WEST SUSSEX COUNTY COUNCIL CONSULTATION

TO:	Arun District Council FAO: Ms M Tomalova
FROM:	WSCC - Highways Authority
DATE:	14 February 2022
LOCATION:	Land to South and West (Rear) of Birchwood House, Church Lane, Barnham, PO22 0DB
SUBJECT:	BN/8/22/PL Retention of existing site entrance (resubmission following BN/97/21/PL. This site is in CIL Zone 3 (Zero Rated) as other development.
DATE OF SITE VISIT:	n/a
RECOMMENDATION:	Advice
S106 CONTRIBUTION TOTAL:	n/a

title
Vision Splay Plan

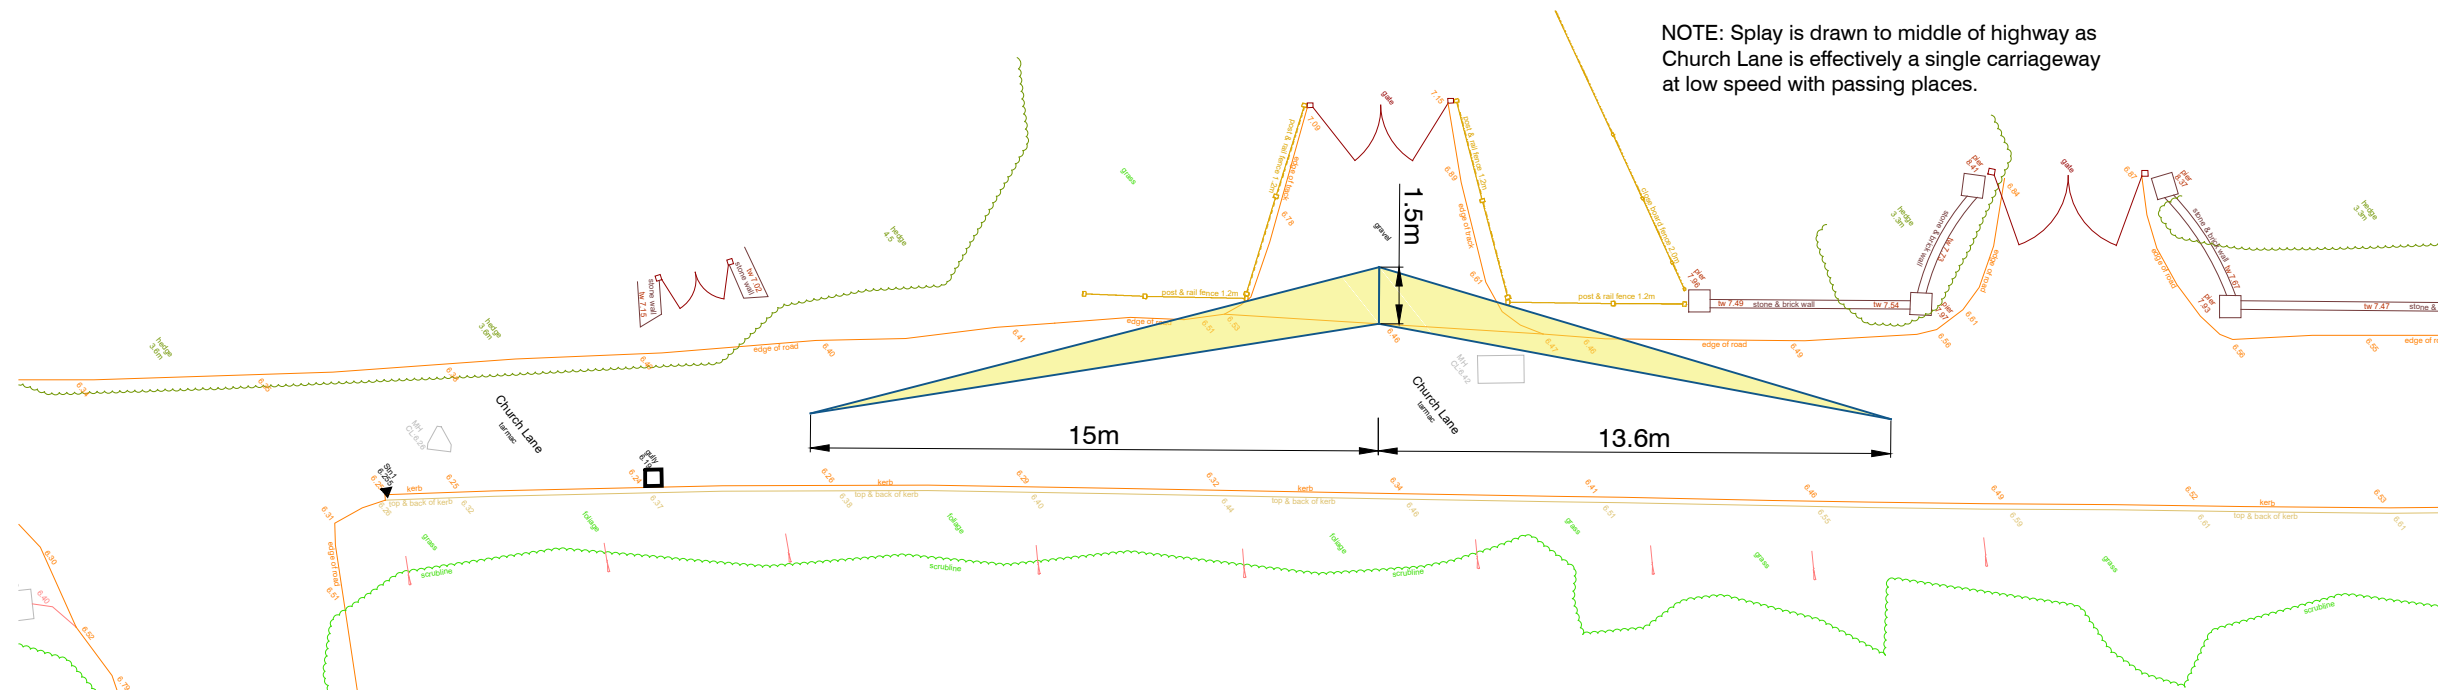
The applied for works have now been in place since August 2020, with no reported issues, which does begin to add weight that regardless of any limitations to visibility that the access is in principle safe and suitable in the wider context of Church Lane.

Consideration is also given to the context of the sites location which is an unclassified road, which is anticipate to be slow speed and low flow. Some consideration can be given that the access in question offers comparative levels of visibility to all the other access points on Church Lane.

Land Registry extract indicating area of land recently transferred into ownership of the applicant.

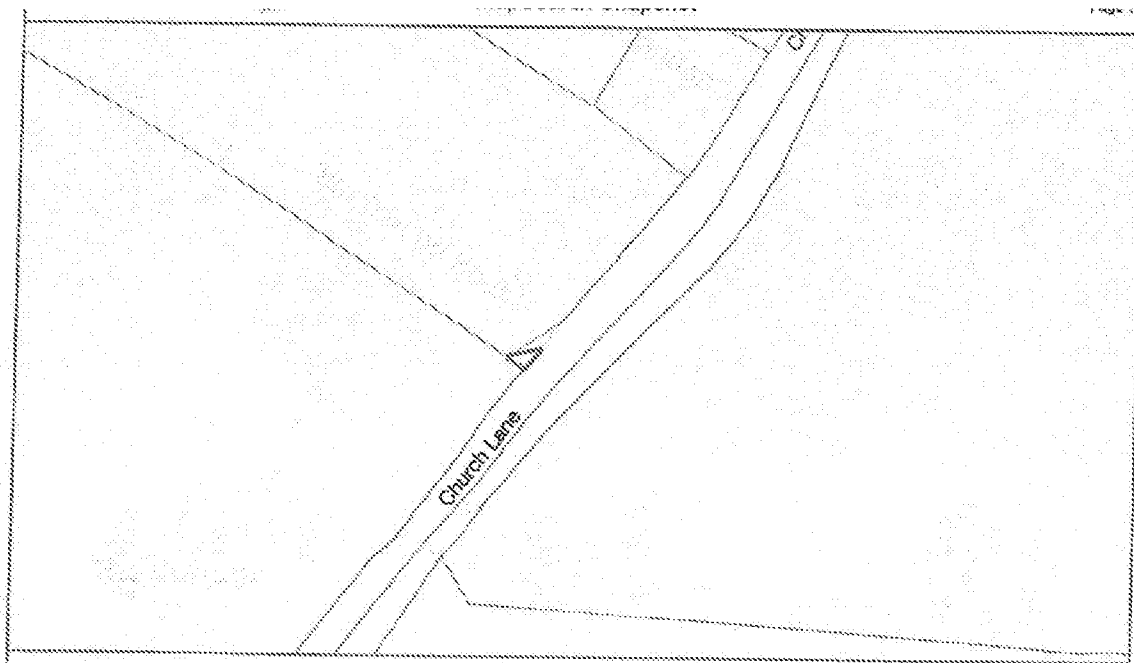
Appendix 2 of the submitted planning statement provides an extract of a title deed that details a historic access gate broadly in the location of the access subject of this application. Appendix 4 of the submitted plan is a statement of an adjoining landowner citing the presence of an access in this location historically. On the balance of probability, the Local Highways Authority accepts that an access likely has existing in this broad location to access and service the land.

Site Layout Plan
Scale 1:100

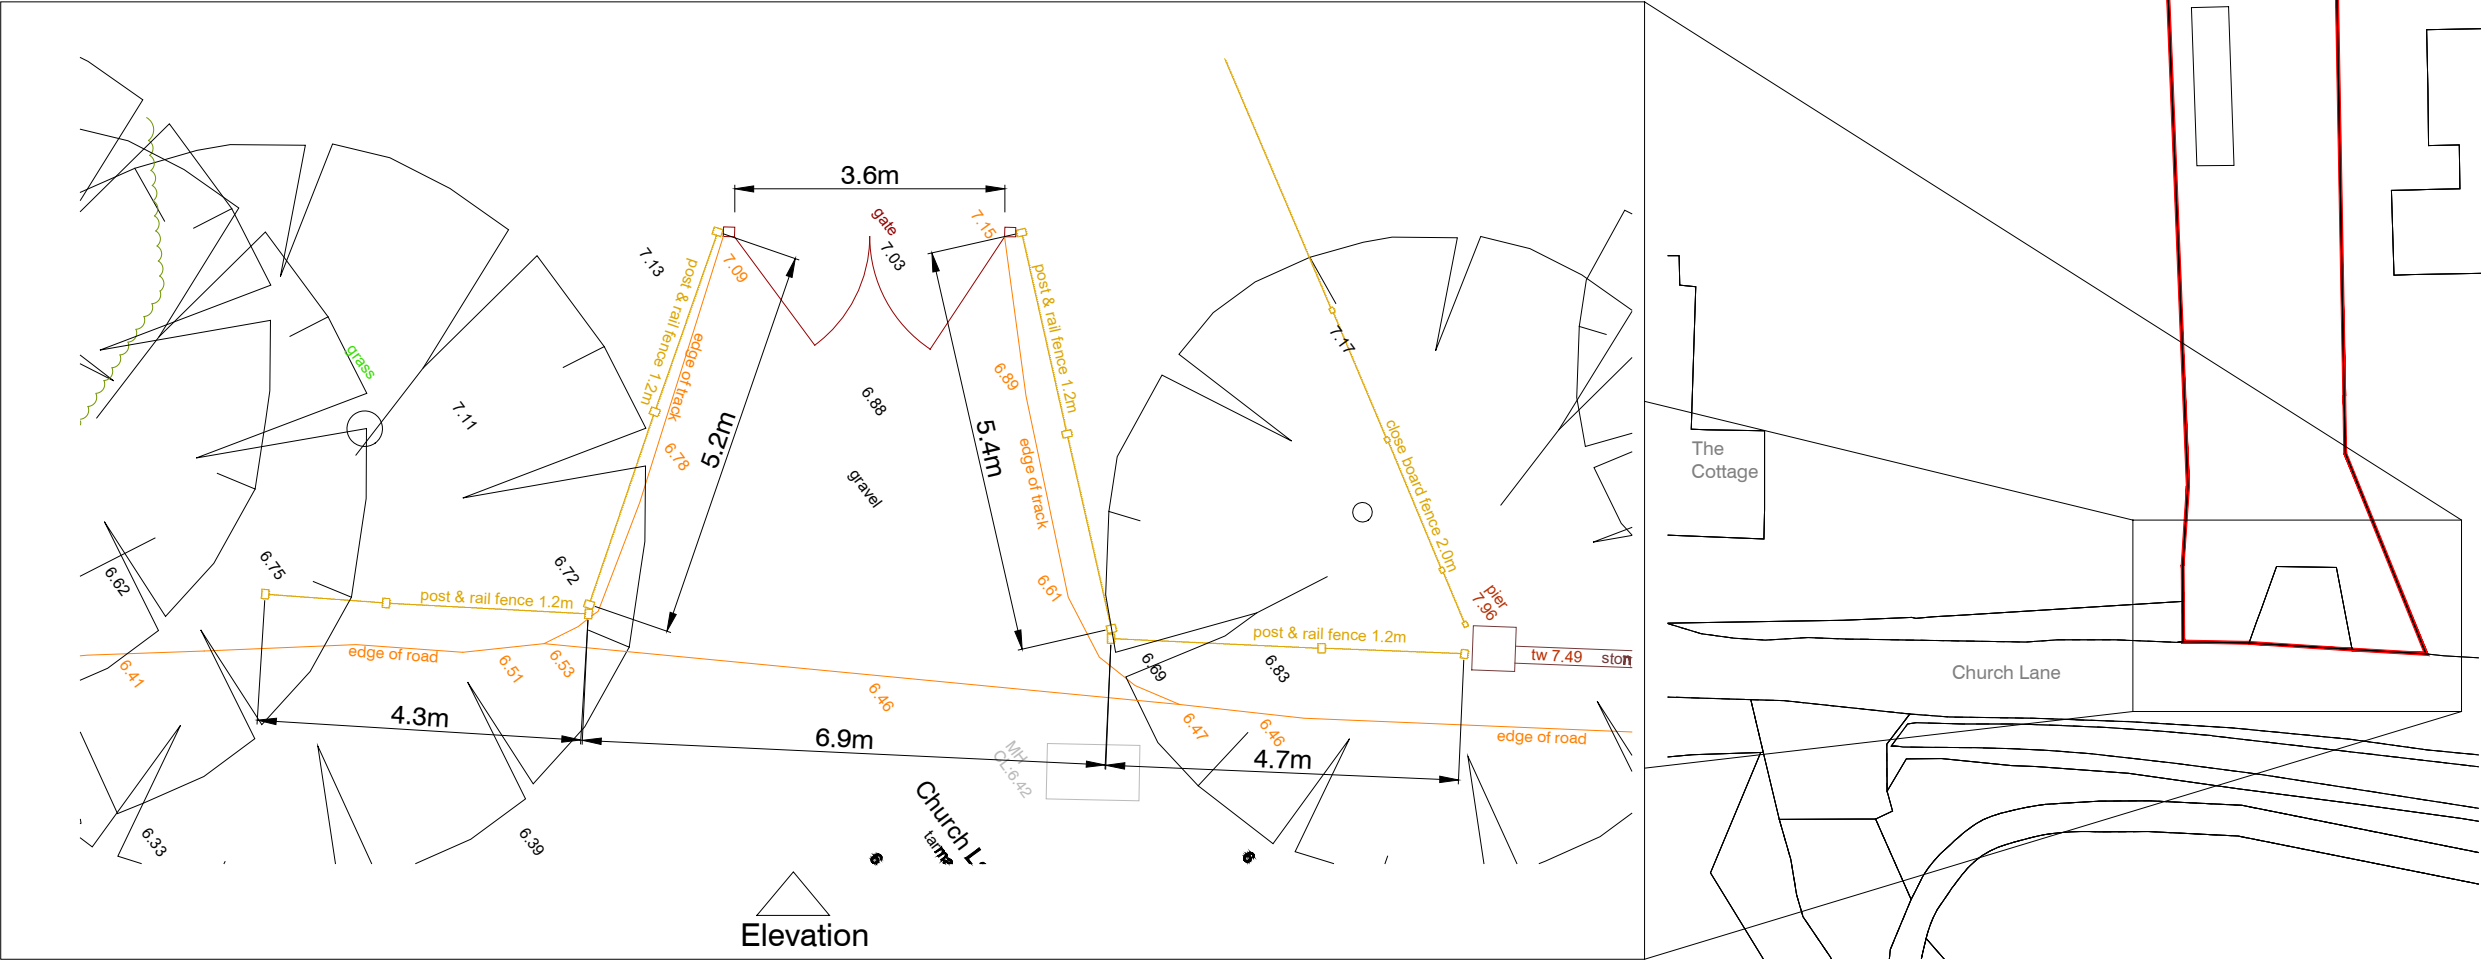
The access crossover, within the extent of the public highway is of a loose construction and does not meet current WSCC crossover specification. The applicant would be invited to retrospectively apply for a crossover licence to regularise the works on the public highway. This will likely require the applicant to resurface the crossover, within the extent of the public highway to current WSCC specification.

The applicant is advised that in addition to obtaining planning permission that they must also obtain formal approval from the highway authority to regularise the construction of the site access works on the public highway. The granting of planning permission does not guarantee that a vehicle crossover licence shall be granted. Additional information about the licence application process can be found at the following web page:
